June 17, 2024

El Paso County
Planning & Community Development Department
2880 International Circle, Suite 110,
Colorado Springs, CO 80910

**Re: *Townhomes at Western PPR-24-15 – Site Development Plan Comment Response Letter
MVE Project No. 61203***

TOWNHOMES AT WESTERN
 LOT I, CIMARRON SOUTHEAST
 FILLING NO - 2C
**SITE DEVELOPMENT
 PLAN
 SITE PLAN**

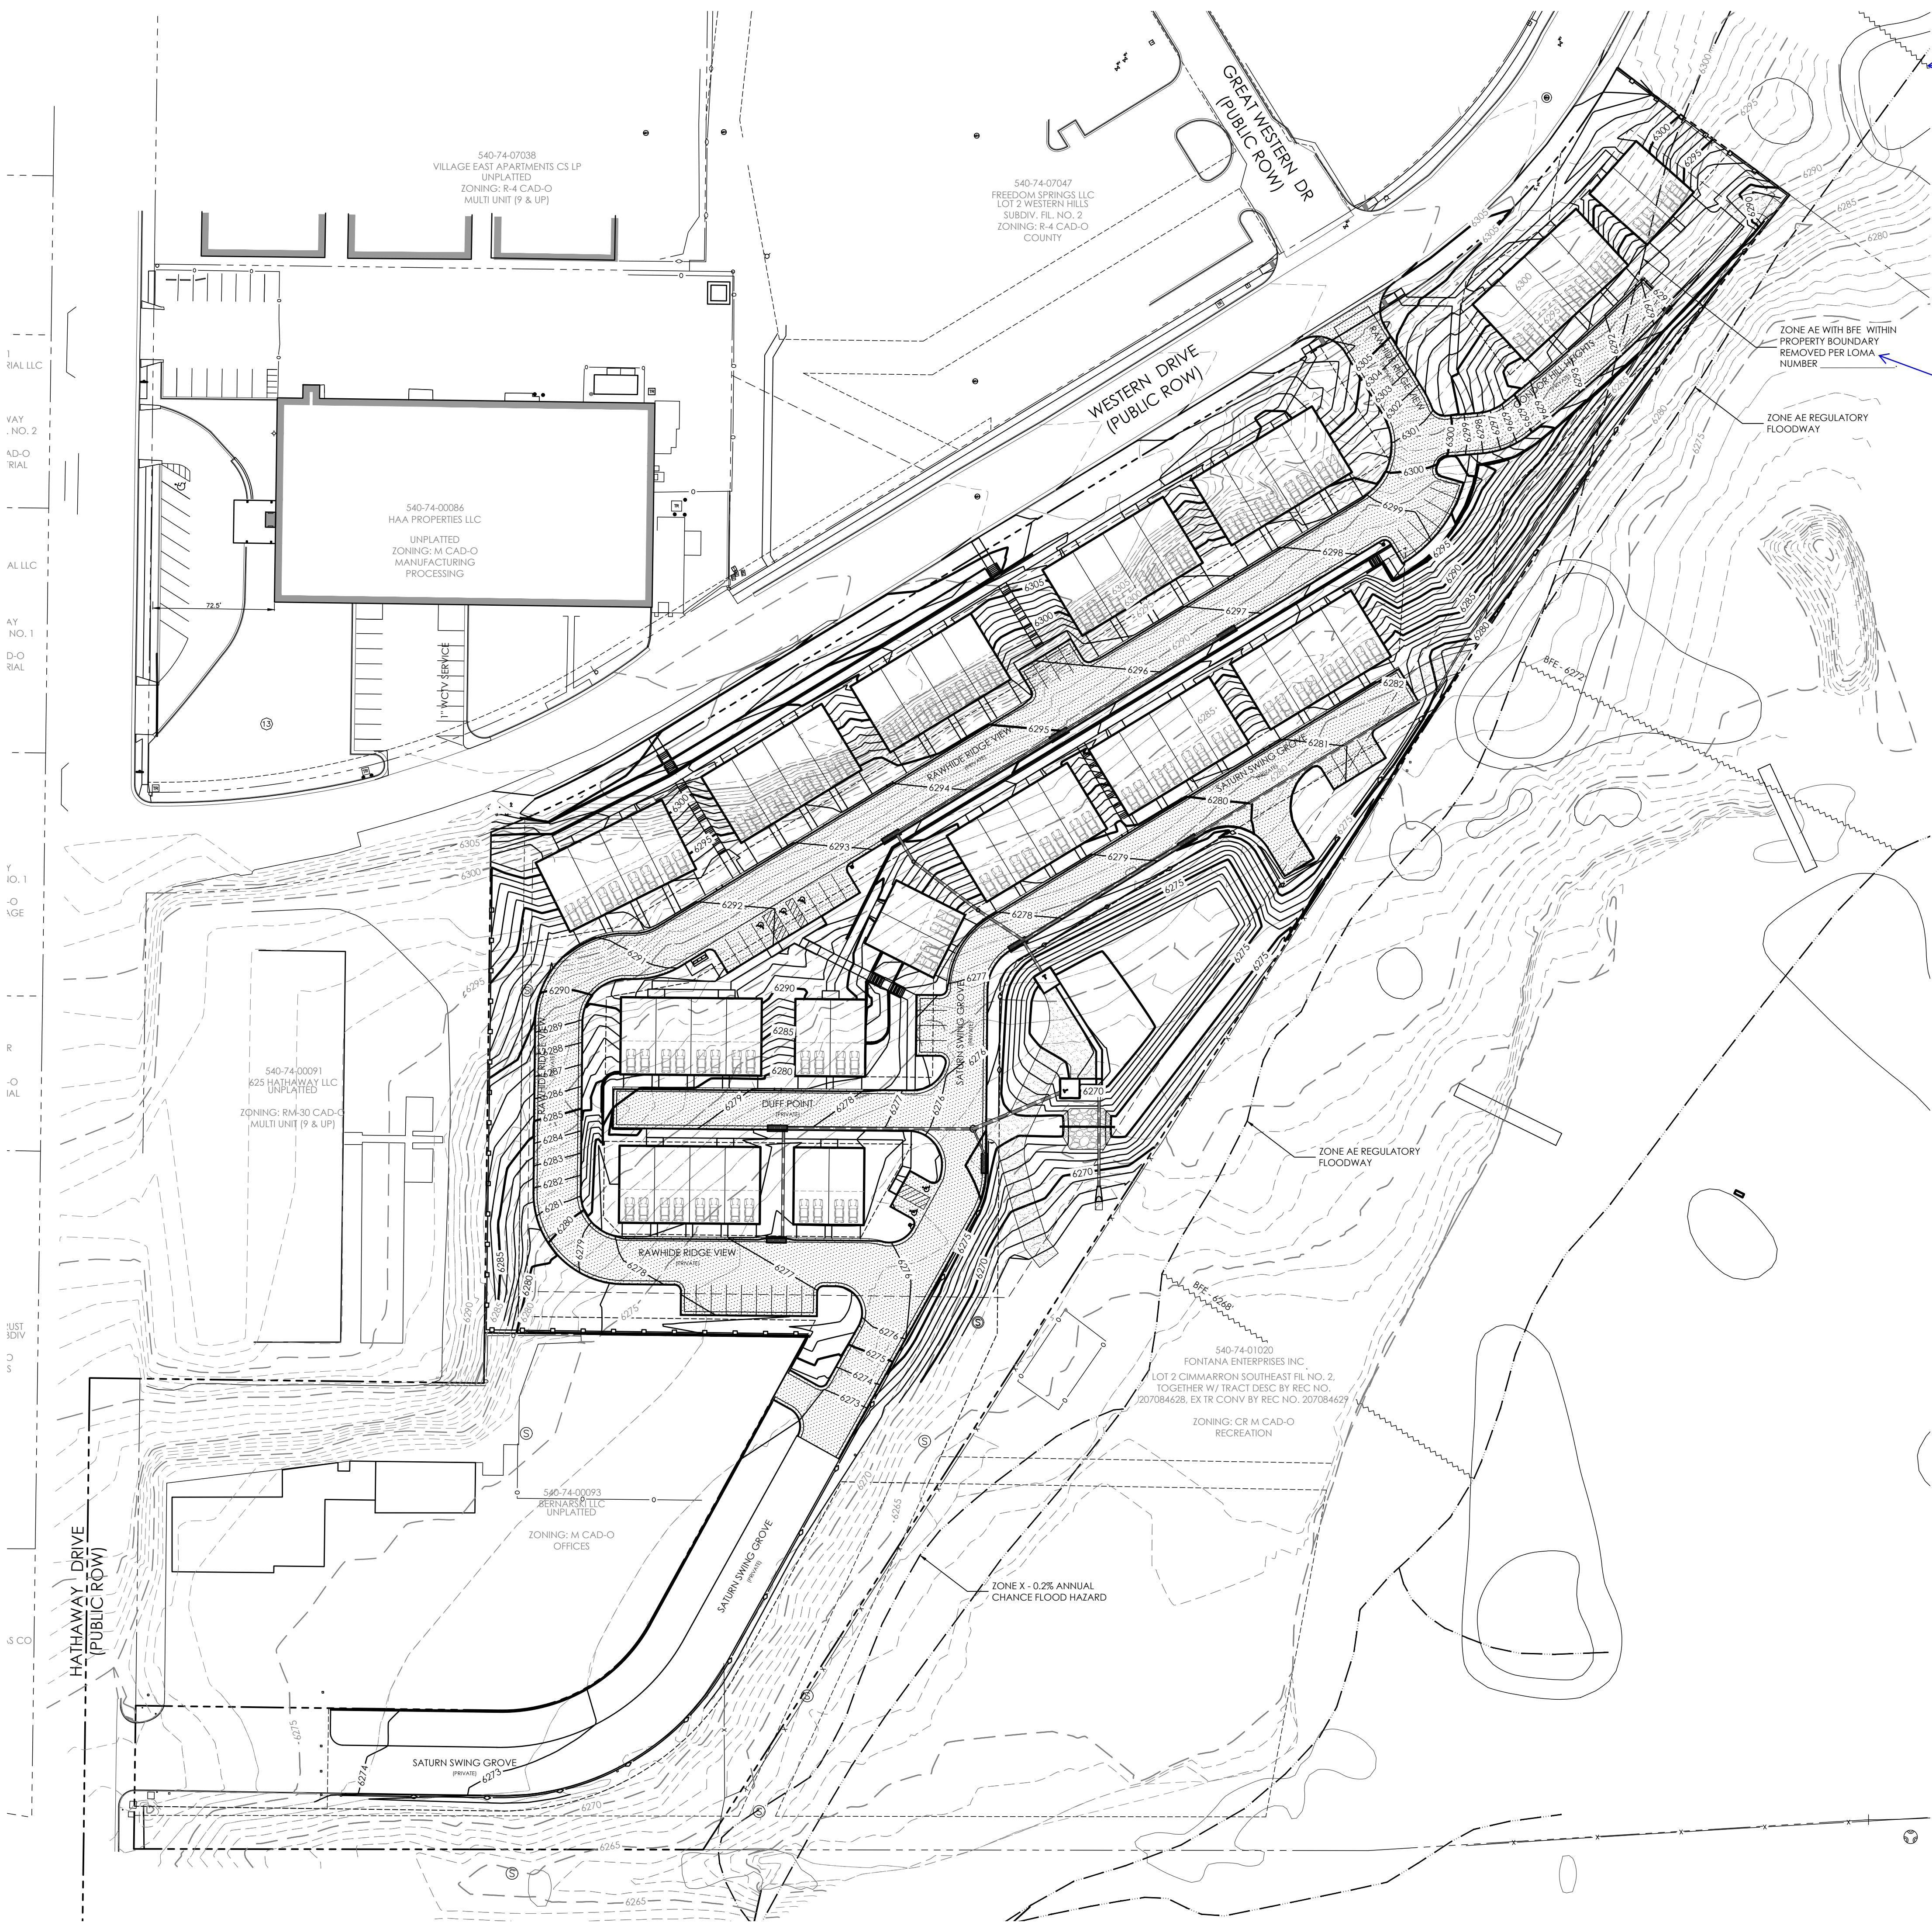
PCD Eng Comment #2: “Per ECM Section 2.3.8 Roadways shall have a turnaround. Please provide deviation.” and “Per ECM, private roads shall be built to EPC standards. Minimum radius for local roadway is 200'. Please provide deviation request.”

MVE Response – Since the Site Development Plan depicts a multi-family condominium type development, the internal drives are not to be considered roads meeting EPC road standards. The internal drives would be treated the same as internal drives and parking areas similar to those in a apartment type complex. We have coordinated with Cherokee Fire Department to address all their comments. A hammerhead turn around was added in one location and some corner radii were revised accommodate fire apparatus requirements and to address Cherokee Fire Department comments. We discussed this in our 6/5/2024 meeting and confirmed resolution by later email.

MVE Response: Please see response and discussion to Letter of Intent comment #1. as the Letter of Intent above. We discussed this in our 6/5/2024 meeting and confirmed resolution by later email.
